**KIRKLEES METROPOLITAN COUNCIL
INVESTMENT & REGENERATION SERVICE**

Reference No: 2020/62/92778/E

Site Address: 15a, Huddersfield Road, Mirfield, WF14 9HN

Description: Erection of two storey rear extension

Client	MISS MALPAS		
Job	15A HUDDERSFIELD ROAD MIRFIELD		
Title	PROPOSED FLOOR PLAN & REAR ELEVATION		
Drawn By	RK	Date	JULY 2020
Eng. Check		Scale	1:50
Tech. Check			
Drawing No.	2020 / 234 / 02		
	Rev.

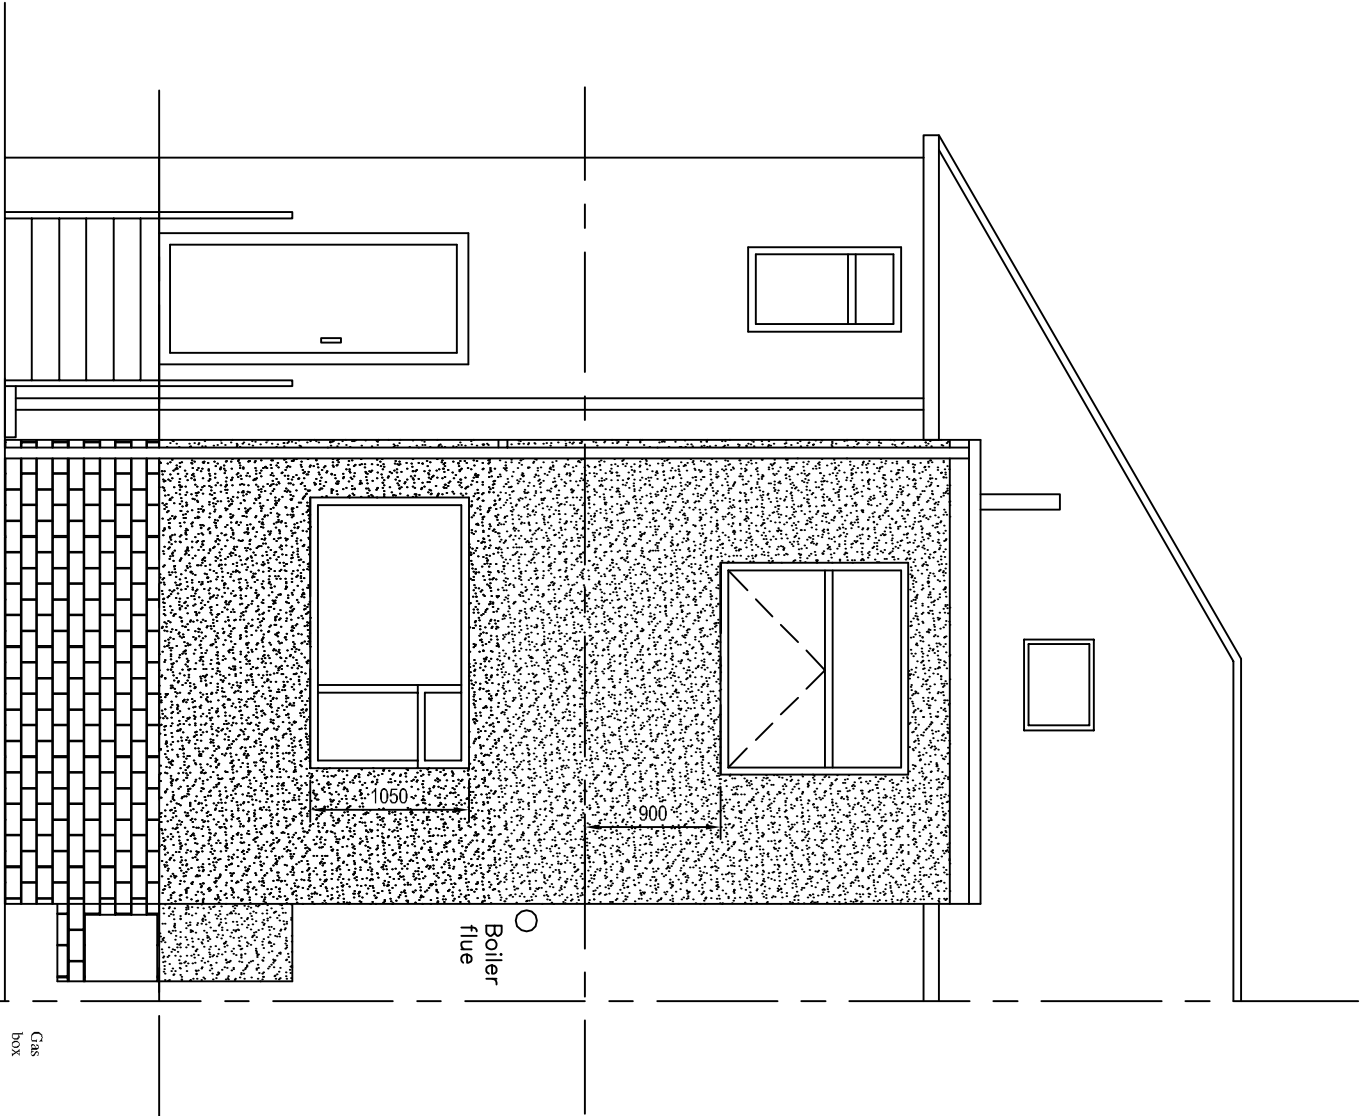
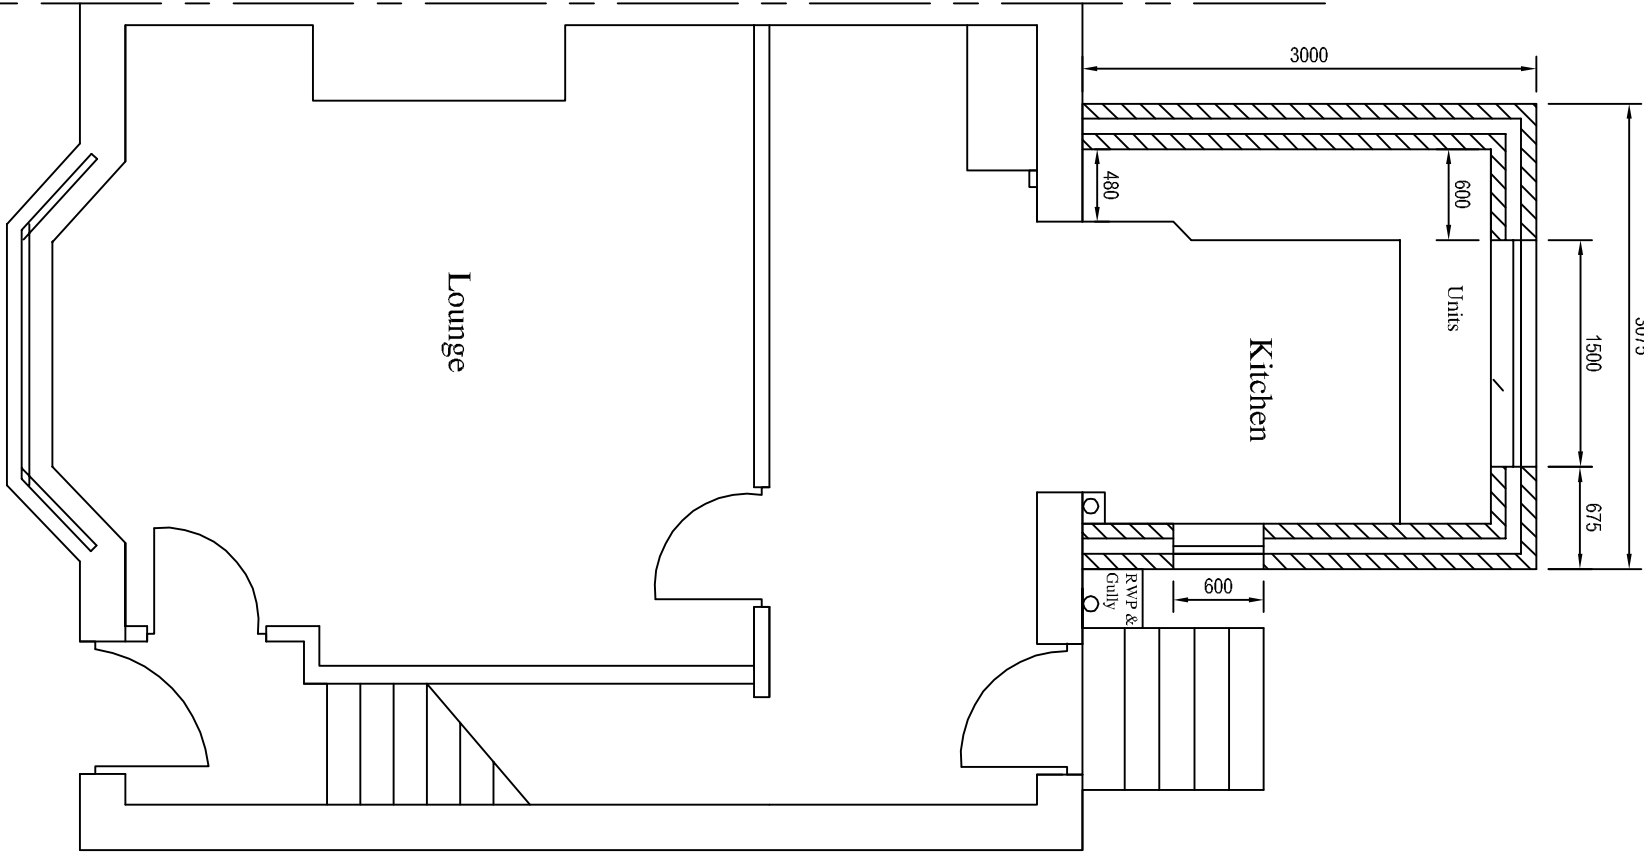
The roof form has been amended to achieve a better design quality. No further amendments were sought thereafter.

The two-storey rear extension would be acceptable in size because its ridge would be set down considerably from that of the main house. The width of this extension would be less than two third of that of the house. Acknowledging this, officers are satisfied that a subservient relationship would be achieved between the rear extension and the host building, in accordance with policy LP24(c) of the KLP.

The facing and roofing materials are pebble-dash render and tiles to match the existing building. As such, there are considered no issues with the chosen materials of construction. The extension would have a dual-pitched roof with two windows in the rear elevation, serving the kitchen and bedroom, respectively. The proposed design and fenestration would be sympathetic to those of the pair of semi-detached houses, resulting in minimal effect on visual amenity and the local street-scene. There would remain a reasonably sized garden to the rear of the application site. In this regard, the proposal would not overdevelop the site.

Client	MISS MALPAS		
Job	15A HUDDERSFIELD ROAD MIRFIELD		
Title	PROPOSED SIDE ELEVATIONS		
Drawn By	RK	Date	JULY 2020
Eng. Check		Scale	1:50
Tech. Check			
Drawing No.	2020 / 234 / 03		Rev.

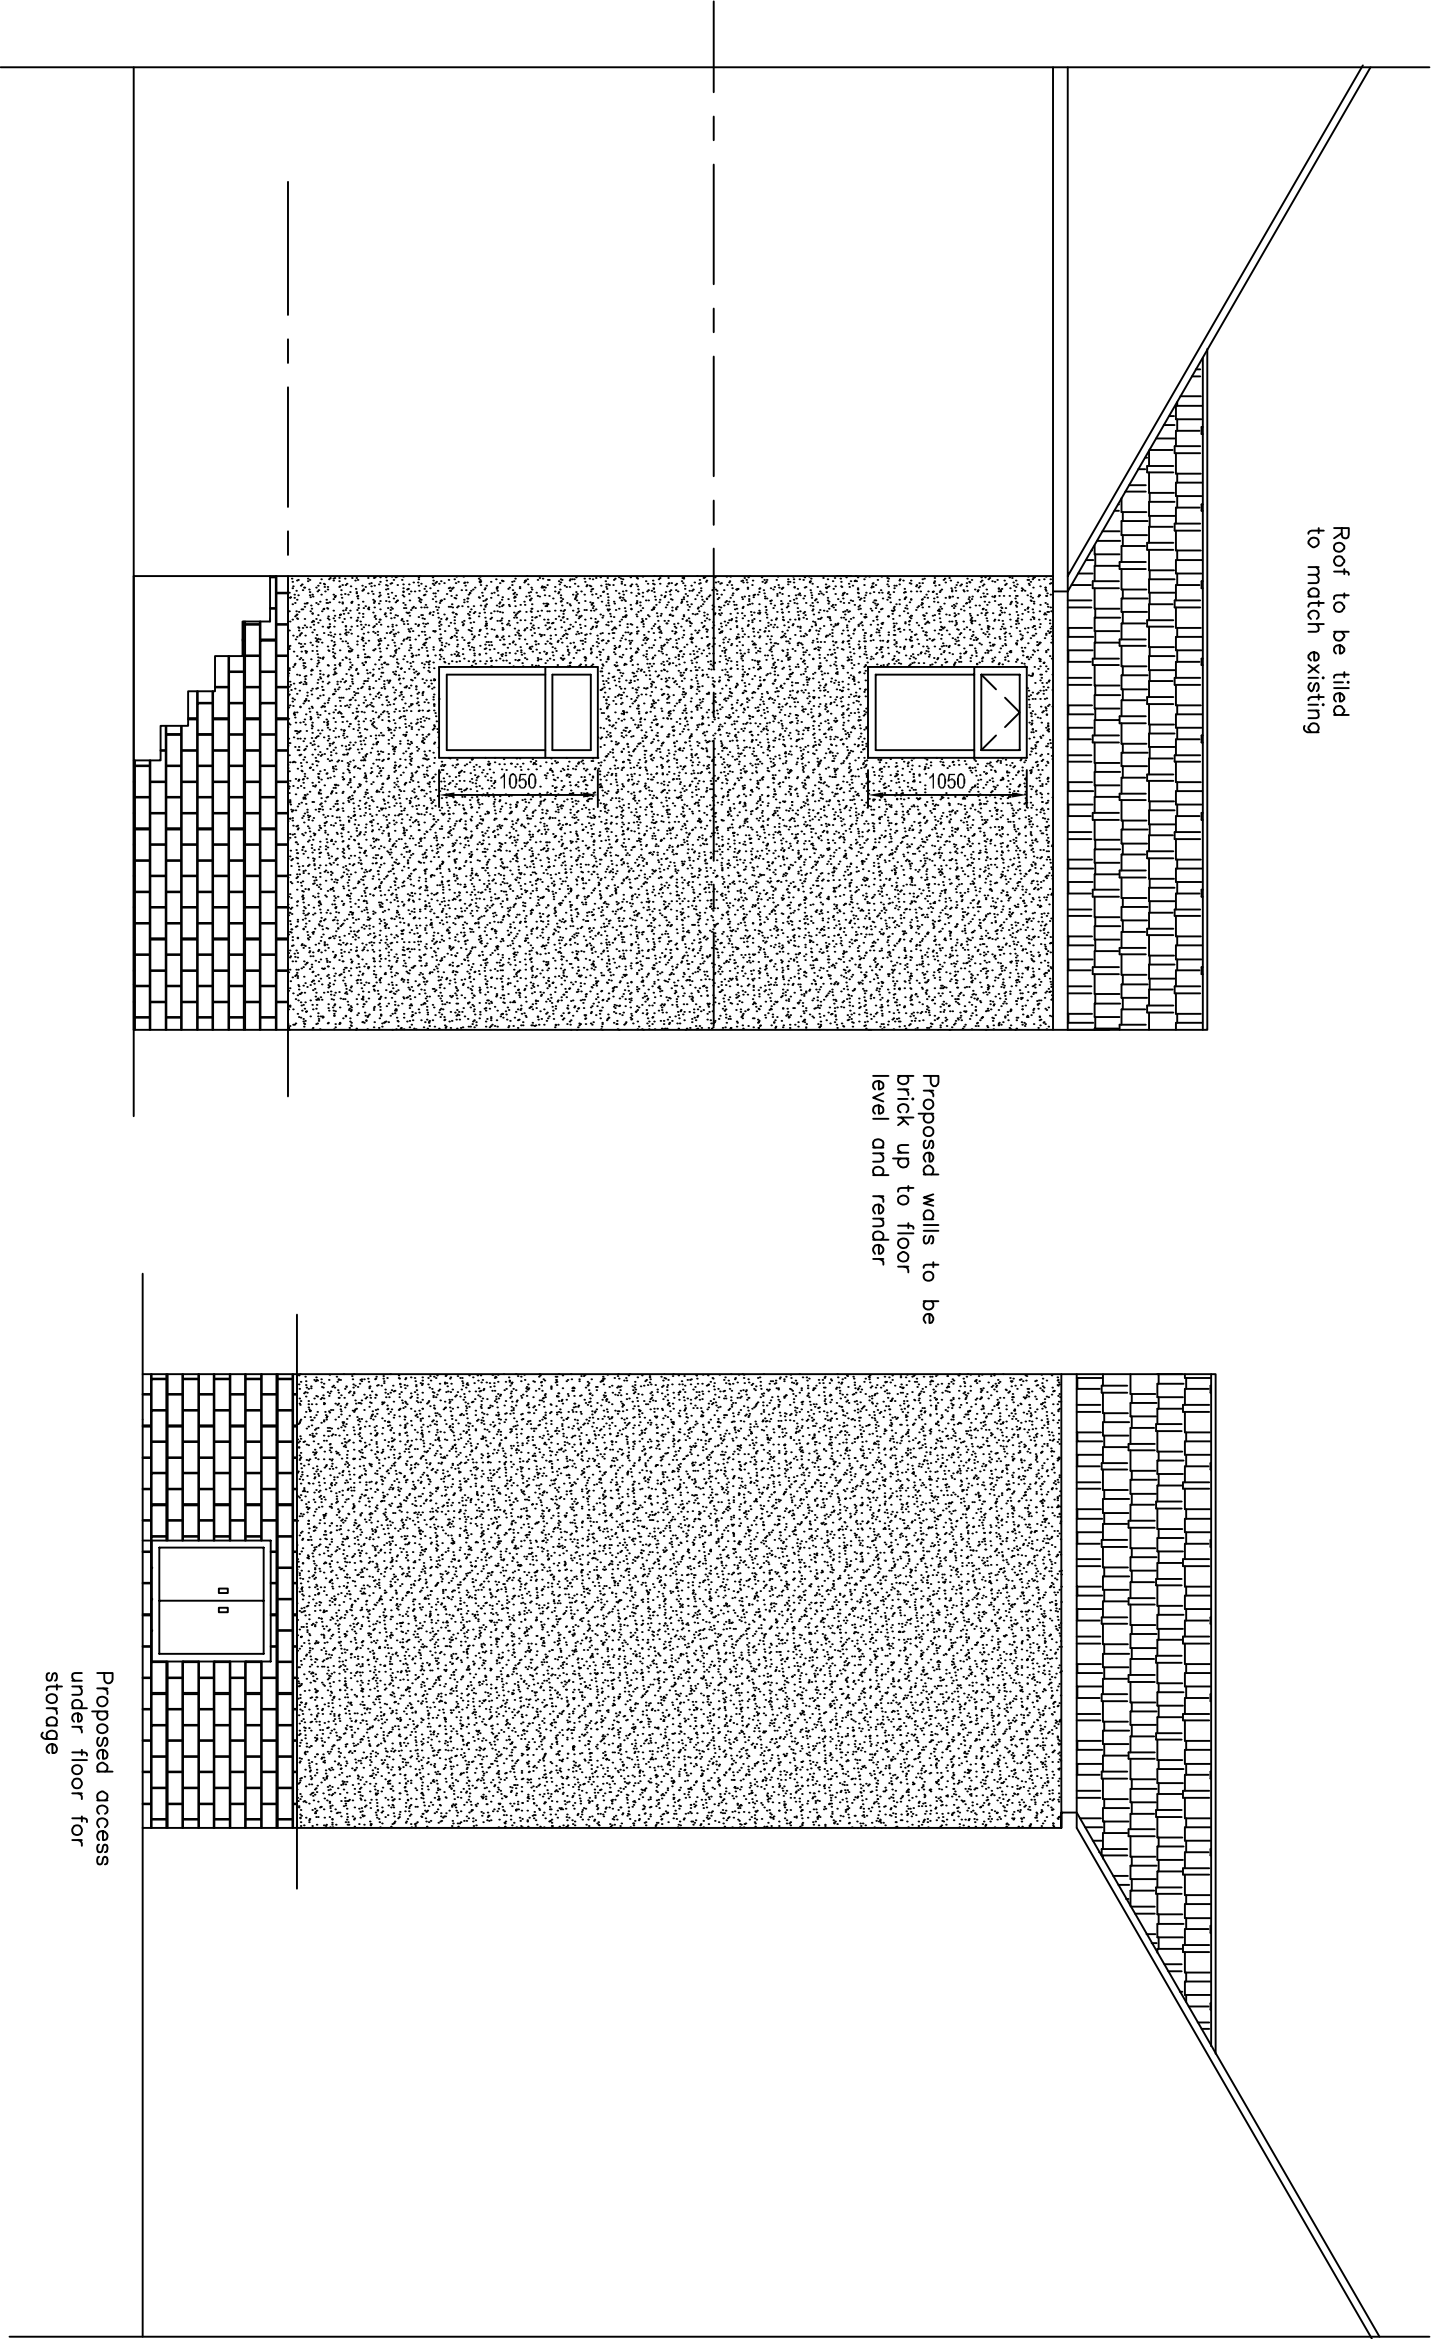
The extension would have no windows in the eastern elevation facing this adjoining site. Thus, no privacy issues would arise from this development. In the interest of residential amenity, a condition would be inserted to withdraw the permitted development rights for insertion of new openings from the side elevation of this extension. With this condition imposed, the development concerned would preserve the living conditions of the occupiers of no.15.

It is noted that the rear extension would have a small window in its side elevation, facing towards no.17. This window would be a secondary habitable room window, serving the enlarged bedroom. To avoid a directly overlooking impact on the neighbours' garden, a condition would be imposed to state that the extension should not be occupied until the side-facing bedroom window has been obscurely glazed to a minimum level 4. It would also require the obscure glazing be retained thereafter. Subject to this condition, it is considered there would be no harm to the residential amenity of these residents.

4. Notwithstanding the provisions of section 55(2)(a)(ii) of the Town and Country Planning Act 1990 and the Town and Country Planning (General Permitted Development) Order 2015 (or any order revoking or re-enacting that Act or Order with or without modification) no new door or window openings other than those expressly authorised by this permission shall be constructed in the eastern and western (side) elevations of the two-storey rear extension at any time without the prior written approval of the local planning authority.

5. The development shall not be occupied until the bedroom window in the western (side) elevation of the two-storey rear extension hereby approved have been obscure glazed to a minimum grade 4. Notwithstanding the provisions of section 55(2)(a)(ii) of the Town and Country Planning Act 1990 and the Town and Country Planning (General Permitted Development) Order 2015 (or any order revoking or re-enacting that Act or Order with or without modification), the obscure glazing (to a minimum grade 4) shall thereafter be retained.
